212058 CFAA

# **Powerhouse Museum Renewal, Ultimo**

## SSD-32927319 Response to Submissions DPE – Flooding

Figure 7 - Proposed Building Envelope Zones (John Wardle Architects)

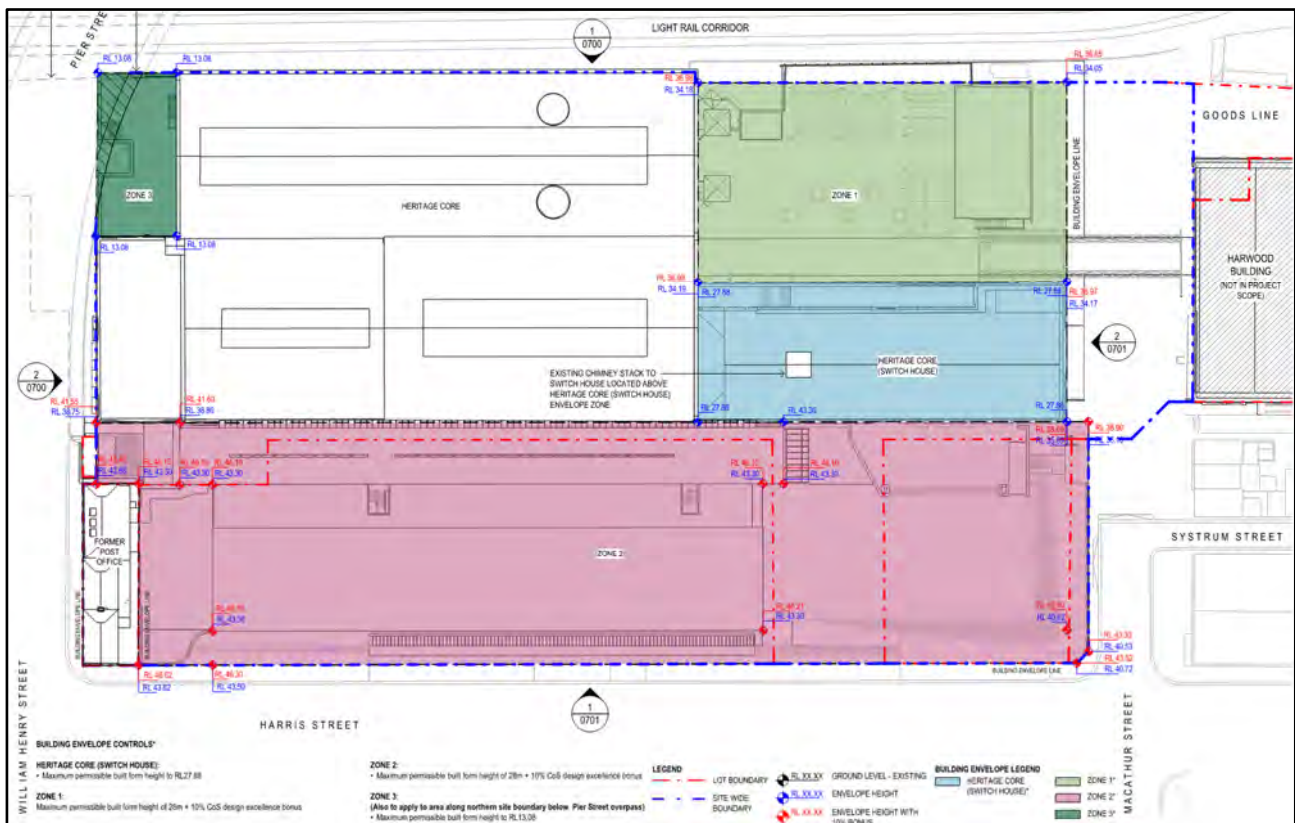
The development of Zone 3 (the northeast corner) is predicted to cause unacceptable flood impacts. Consideration should be given to retaining this area at existing ground levels or reducing the planned extent of the building to avoid impacts. It is not considered reasonable to proceed based on the predicted impacts. The feasibility of any proposed mitigation measure must be shown, noting that stormwater upgrades in this environment even if feasible, would likely be costly.

Development of zone 3 is not expected to cause any significant impact in flood behaviour. There is an existing brick wall that runs along the northern boundary of this area, which would block overland flow entering this area in the existing condition. Refer to survey and site photos shown in figure 1. This existing brick wall has been included in the existing scenario flood model. The development of zone 3 is fully behind this existing brick wall and would not change the overland flow paths which would not enter the zone 3 Area. The existing scenario was updated to include this wall with the results shown in figure 2. The post development flood results with development of the zone 3 area is shown in figure 3.

The post development flood impact map in figure 4 shows localised impacts, but this is due to interpolation at the edges of the flood model grid. Further detailed assessment will be included in the Stage 2 SSDA and will include more detailed topographical survey, and more detailed investigation of the existing and stormwater within and around this area.

Figure 23 – Proposed Flood Impact - Conservative Assessment Of Full Development Of Building Envelopes

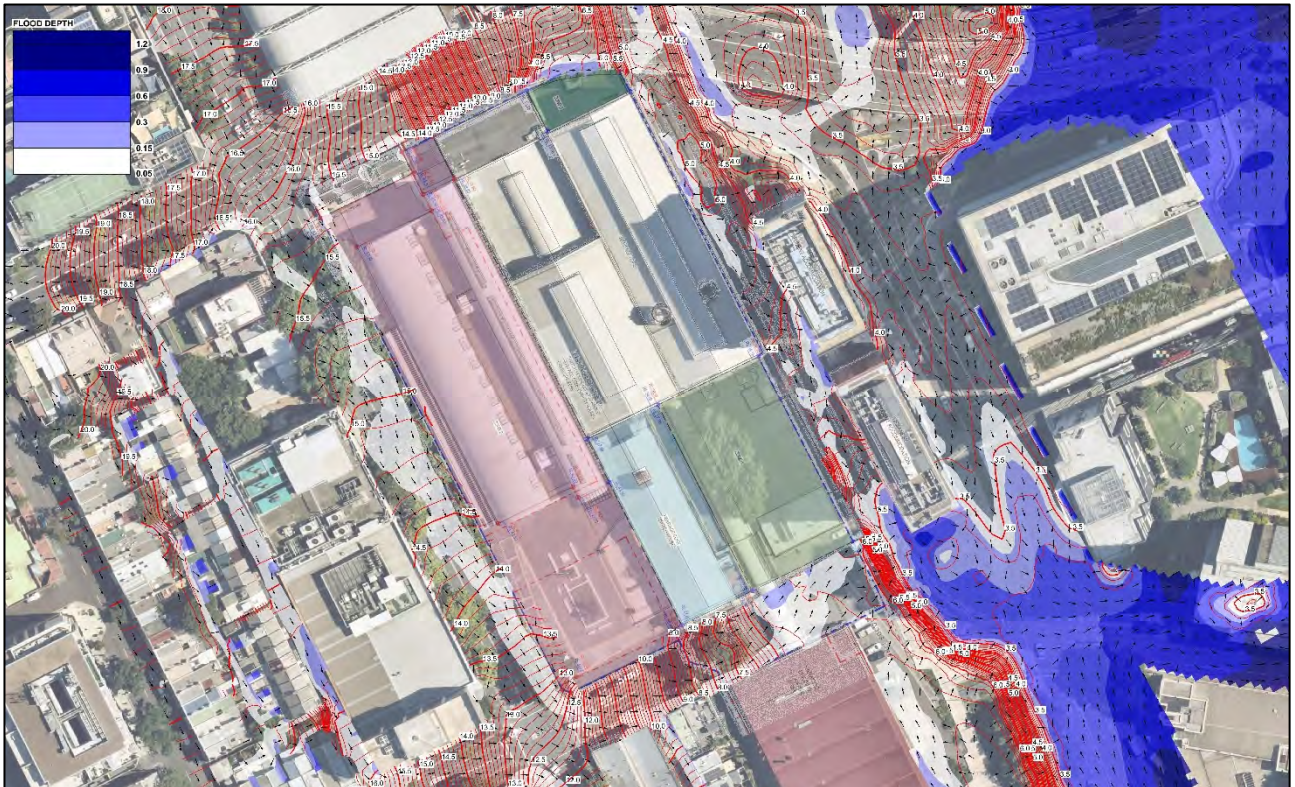
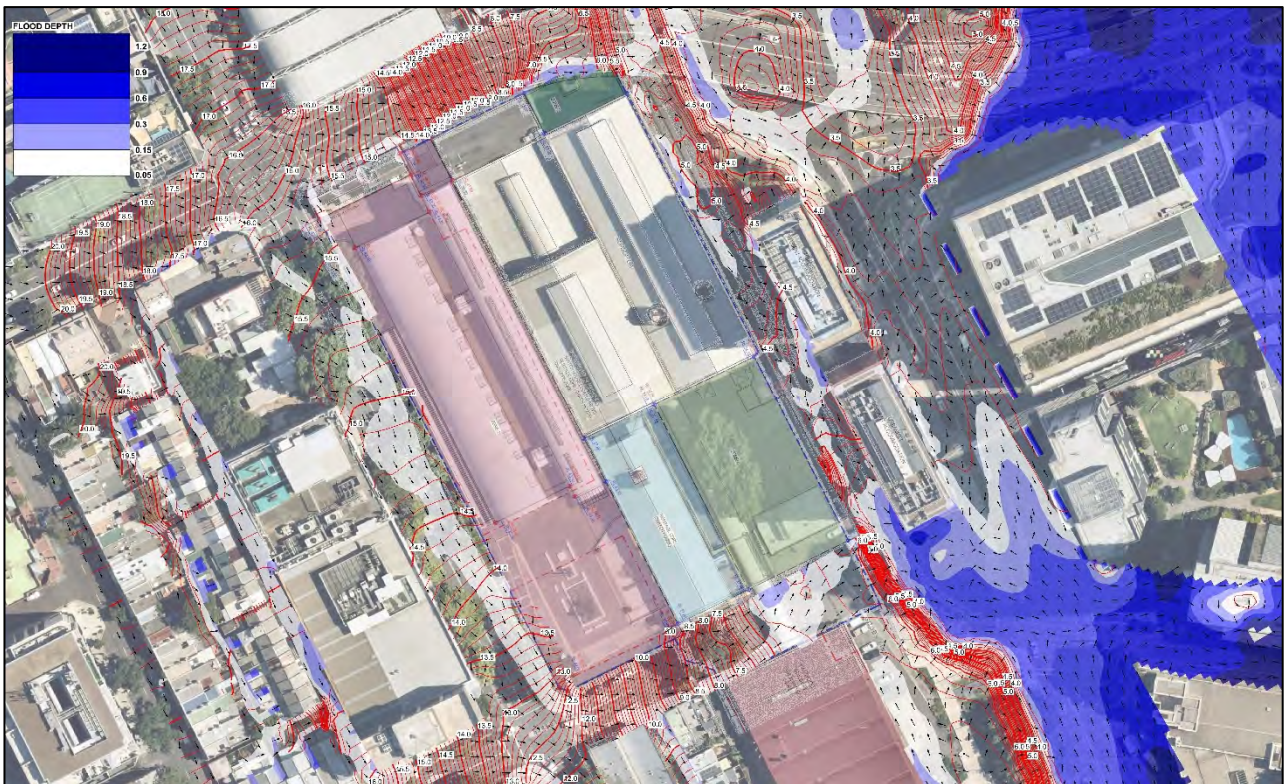
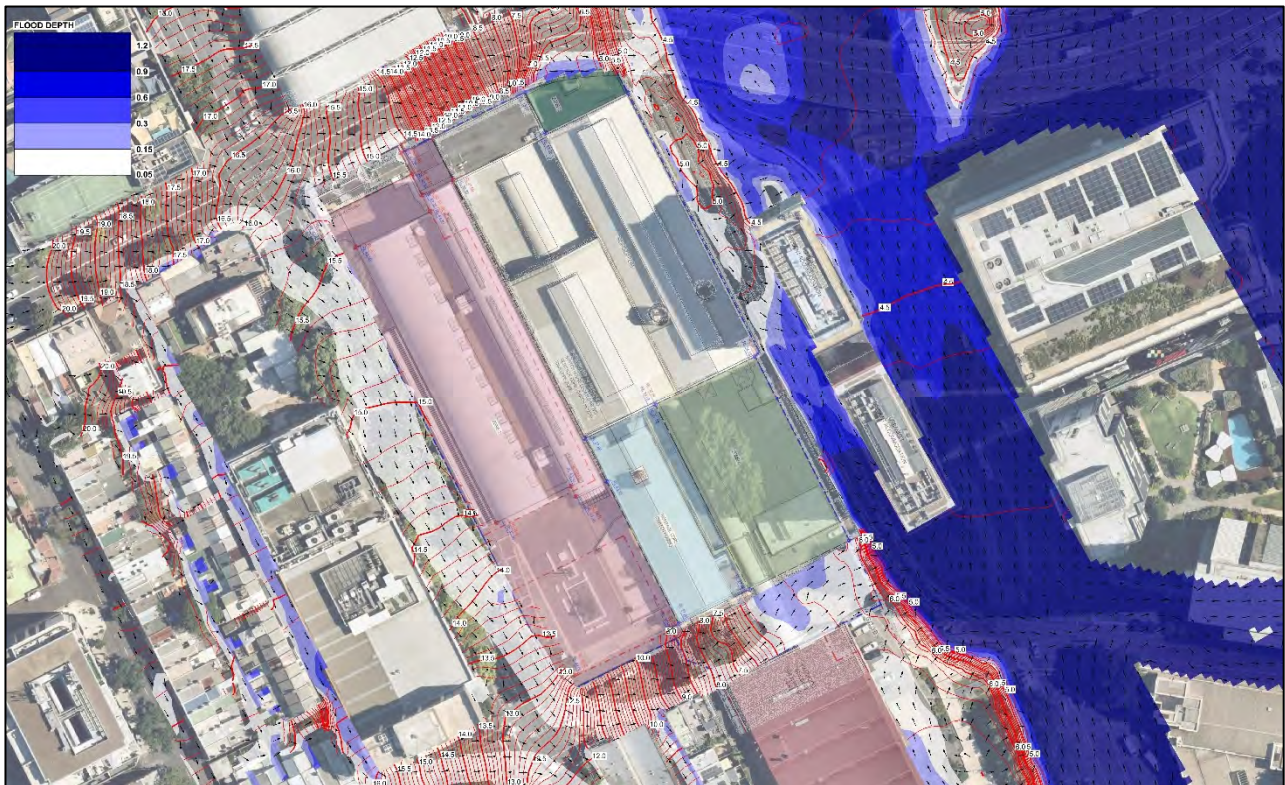
A flood impact assessment has been provided as requested. However, EHG does not consider that the information provided enables a proper assessment. The flood impact assessment only shows impacts greater than '0.05', which is assumed to be in metres. The flood impact assessment must be updated to show impacts greater than 0.01m or 10mm, the generally accepted limitation of accurate modelling.

EHG considers that displaying only impacts of 0.05m or above may hide true impacts. The loss of floodplain storage and conveyance across the southeast portion of the project site may lead to impacts. Considering the serious flood affectation of downstream properties, this should be addressed.

The flood impact assessment previously completed is deemed to be suitable for a Stage 1 Concept SSDA and provides suitable analysis and assessment of the existing and post development flood behaviour. As discussed in the original report, a more detailed modelling assessment will be included as part of the detailed Stage 2 SSDA. However, the model results have now been updated to show flood impact results within the +/- 10mm range rather than the original +/-50mm, refer to figure 4.

**Response to Paragraph 2.** Flood model results have been updated to now show flood impact results within the +/- 10mm range rather than the +/-50mm range, refer to figure 4. The updated results show that there is no significant impact downstream or to adjacent properties. There are very localised changes in flood level, but these are most likely due to interpolation at the edges of the flood model grid adjacent to nulled cells. There is no significant impact to flood behaviour outside the development site due to the loss of floodplain storage to the southeast of the development site, there is localised flood affectation within the site boundary that will be managed through appropriate flood planning levels of the development and proposed stormwater during the Stage 2 SSDA. Further detailed assessment will be included in the Stage 2 SSDA and will include more detailed topographical survey, and more detailed investigation of the existing and stormwater within and around the development site.
